Application Ref:	3/2026/0537			 Ribble Valley Borough Council www.ribblevalley.gov.uk
Date Inspected:	07/08/2026	Site Notice:	07/08/2026	
Officer:	MC			
DELEGATED ITEM FILE REPORT:				APPROVAL

Development Description:	Proposed glazed sliding door to south elevation.
Site Address/Location:	Bobbin Hall, Shire Lane, Hurst Green, BB7 9QR

3 Proposed - South Elevation
Scale: 1:100

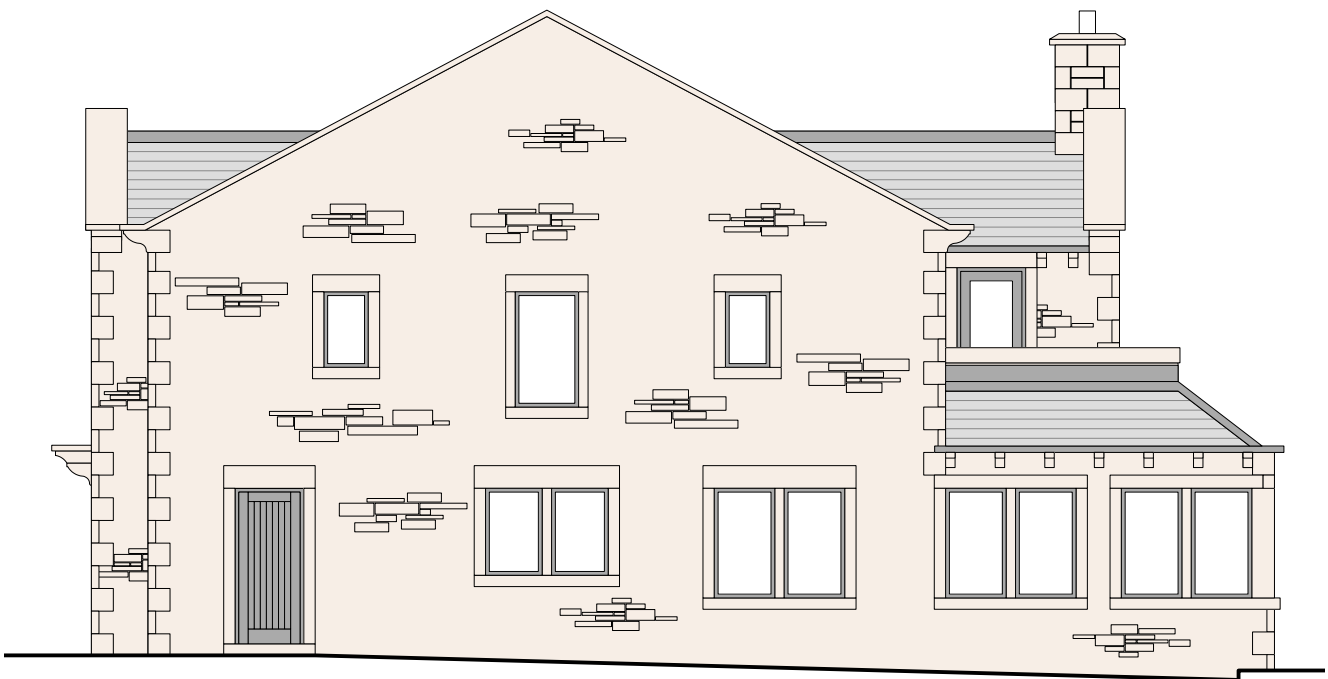
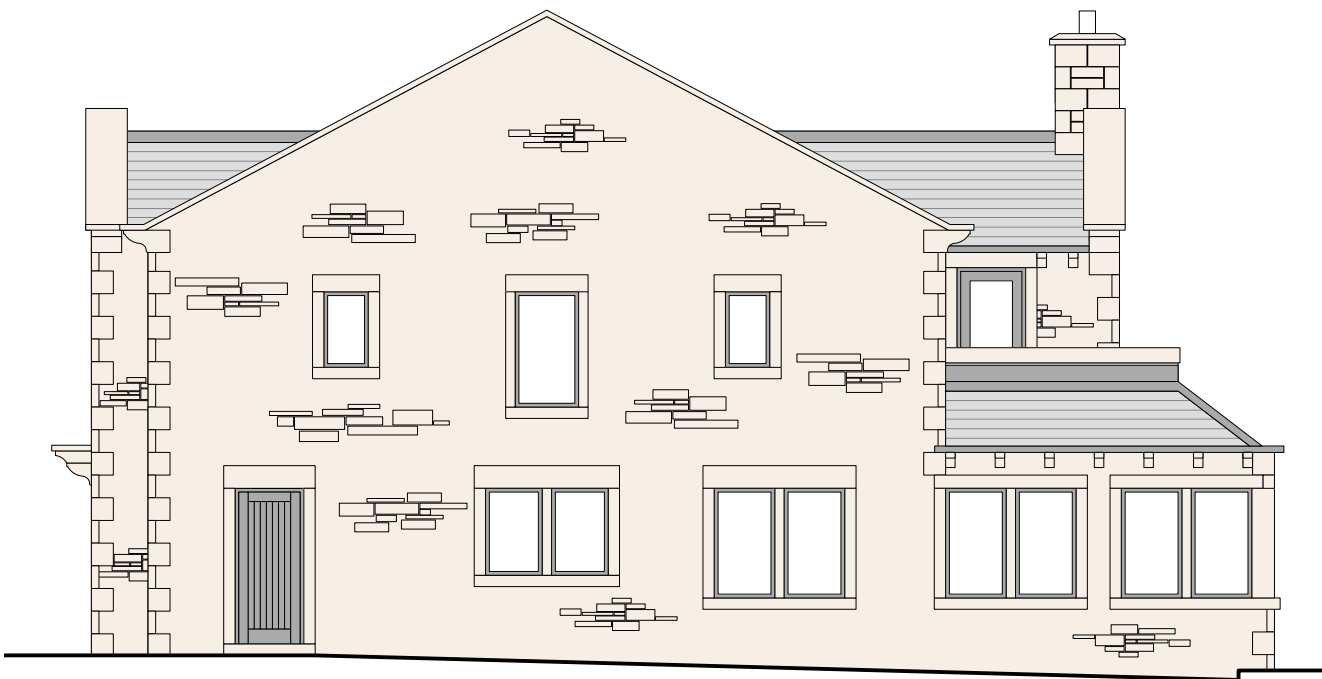
The proposed new doors are considered to be of an appropriate size and scale to the rear of the dwelling. The proposed doors would be aluminium and whilst timber would be the preferred material within the Forest of Bowland National Landscape as it is more traditional in appearance, the agent has confirmed that the colour would match the existing windows on the house. The windows are located to the rear of the dwelling and would not be highly visible from any public vantage points. As such, on balance, aluminium is considered to be acceptable in this location.
